WEST SUSSEX COUNTY COUNCIL CONSULTATION

TO:	Arun District Council FAO: Obafemi Okusipe
FROM:	WSCC - Highways Authority
DATE:	22 February 2022
LOCATION:	Selwood Lodge Hotel 93 Victoria Drive Bognor Regis PO21 2DZ
SUBJECT:	BR/29/22/PL Change of use from C1 Guest House to a 16 bed House in Multiple Occupation (Sui Generis) including first floor extension, demolition of existing detached garage and external alterations.
DATE OF SITE VISIT:	n/a
RECOMMENDATION:	No Objection
S106 CONTRIBUTION TOTAL:	n/a

PROPOSED SITE PLAN  
1:100

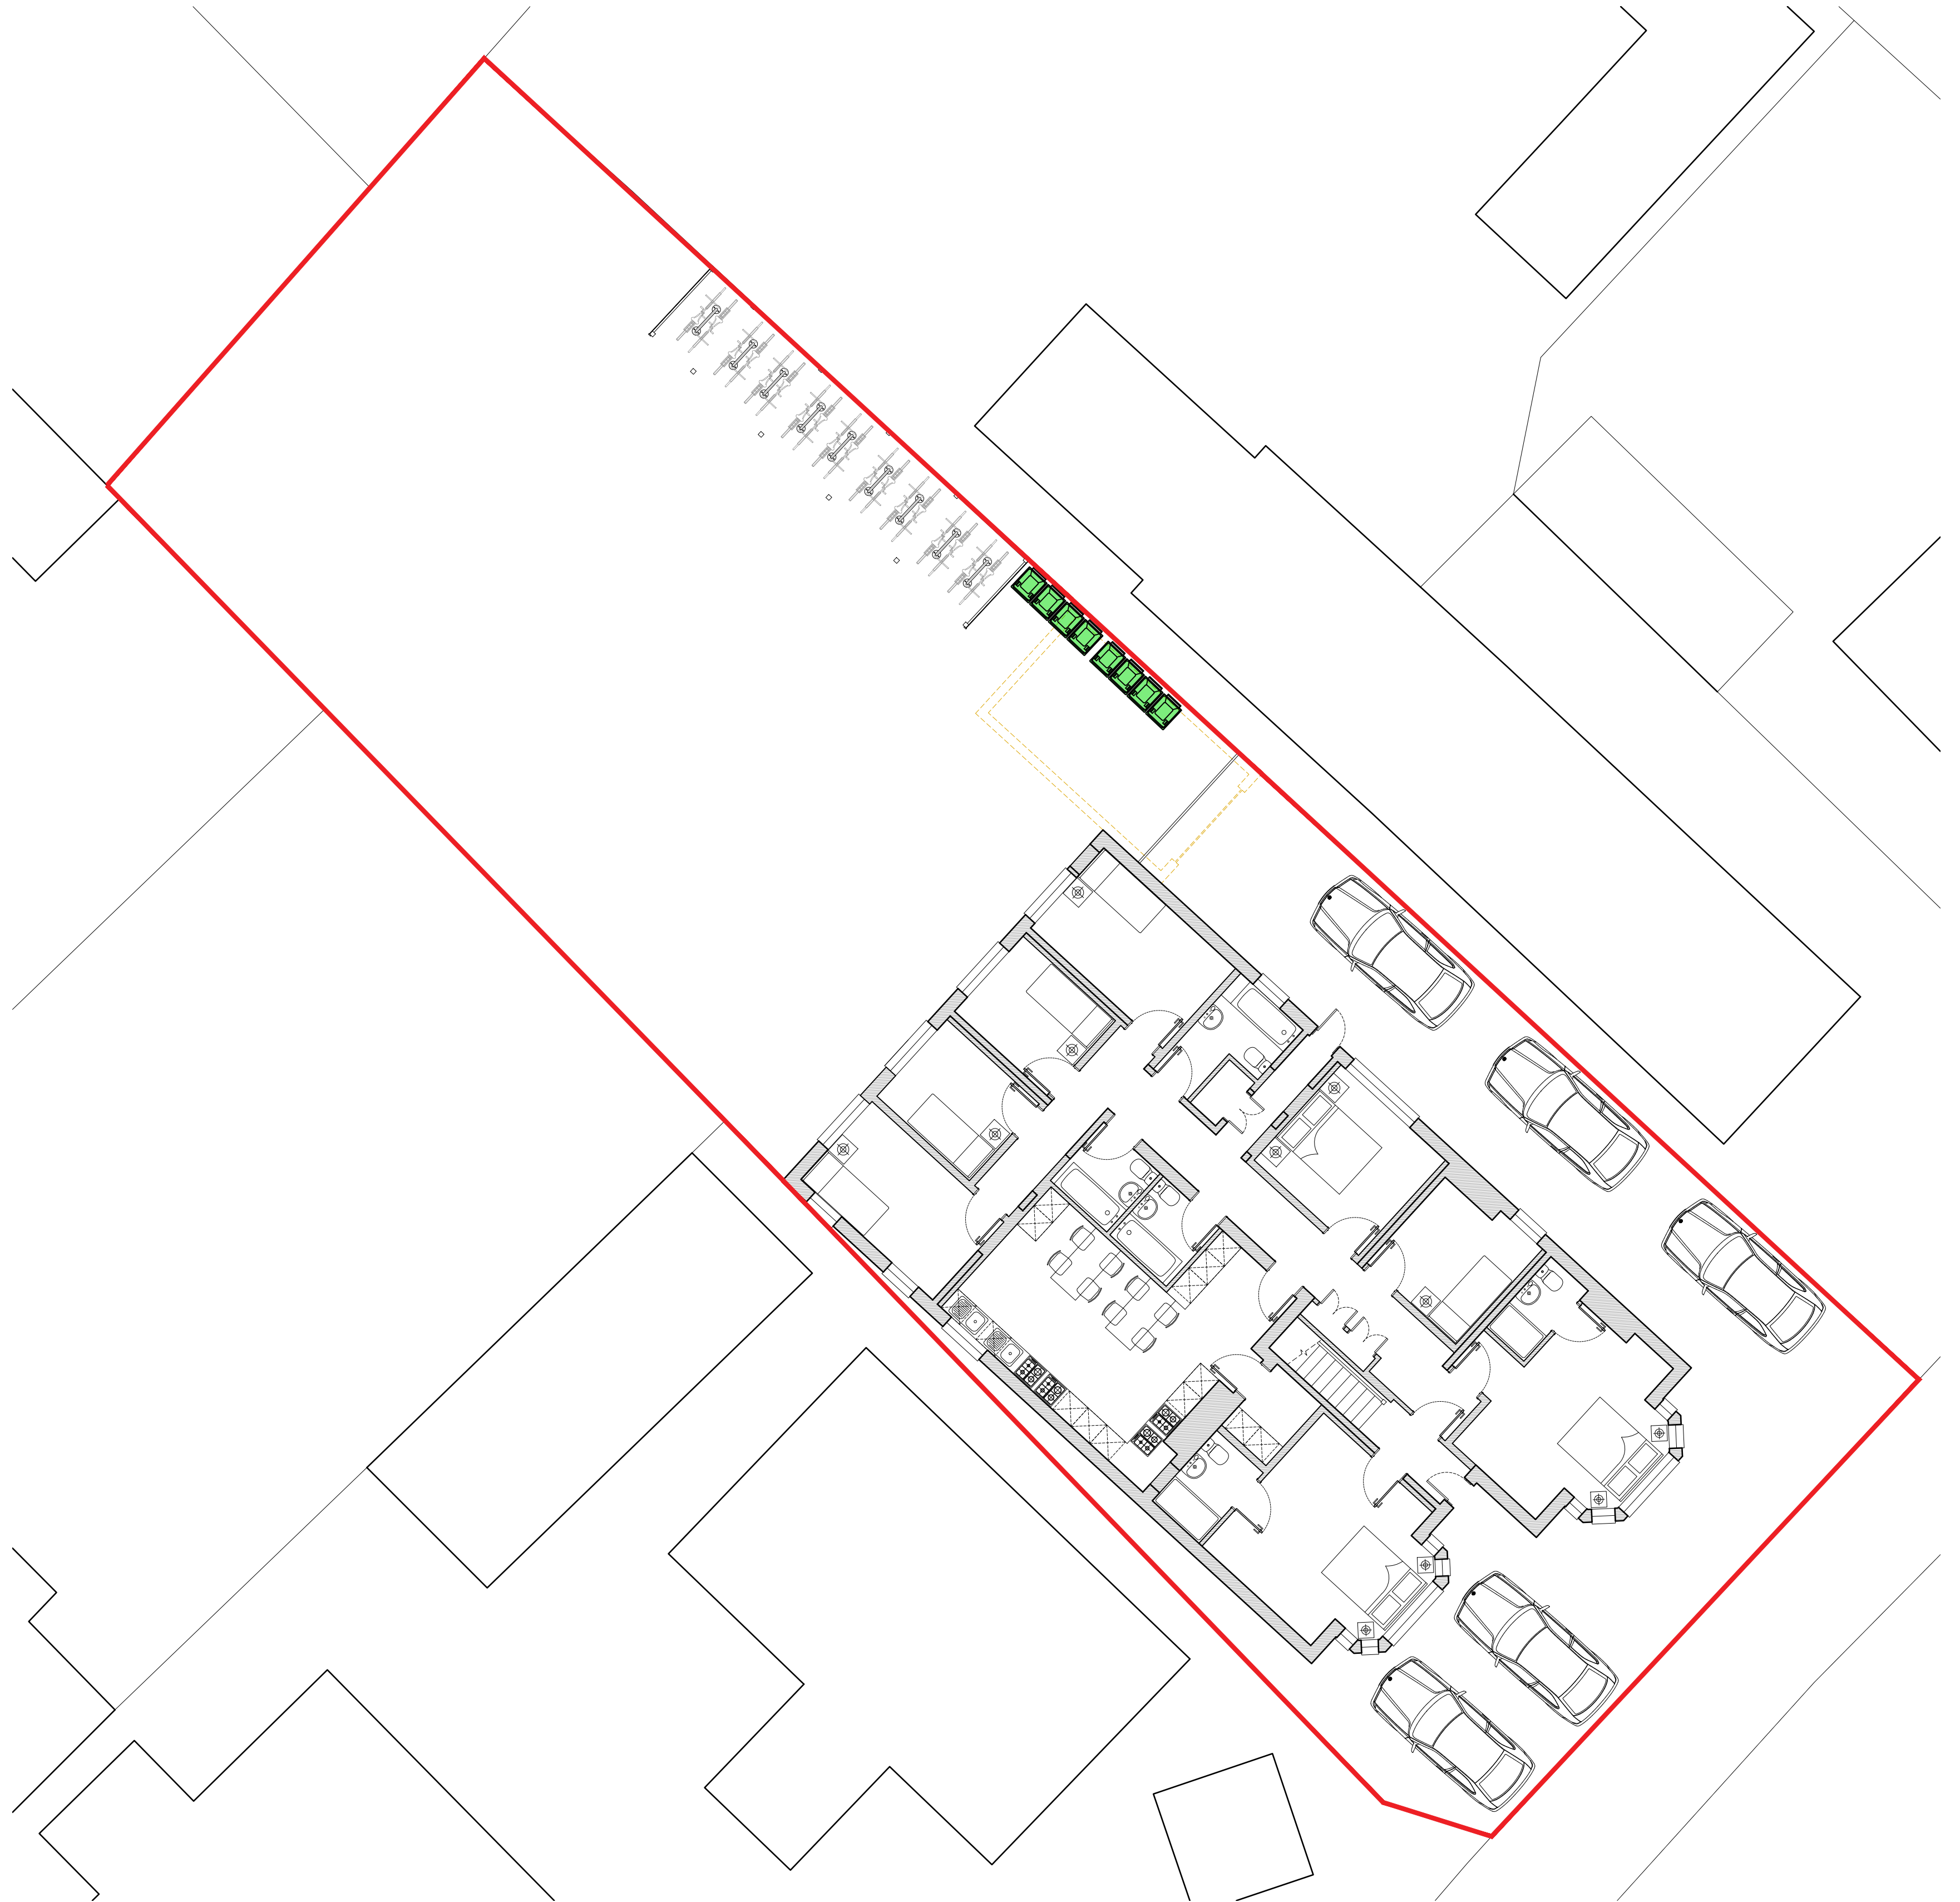
The development will be made car free with the exception of a single vehicle parking space which will be retained for future use. This is justified given that the site is in a very sustainable location. Bognor Regis town centre and train station are situated within 300 metres of site. Bus stops located along Victoria Drive provides connectivity to nearby places. To encourage sustainable travel safe and secured cycle storage spaces for 18 nos. bicycles are provided at the rear of the property. Refuse collection will be carried out from the kerbside on the day of collection, in line with the existing arrangements.

No part of the development shall be first occupied until covered and secure cycle parking spaces have been provided in accordance with plans and details submitted to and approved by the LPA.
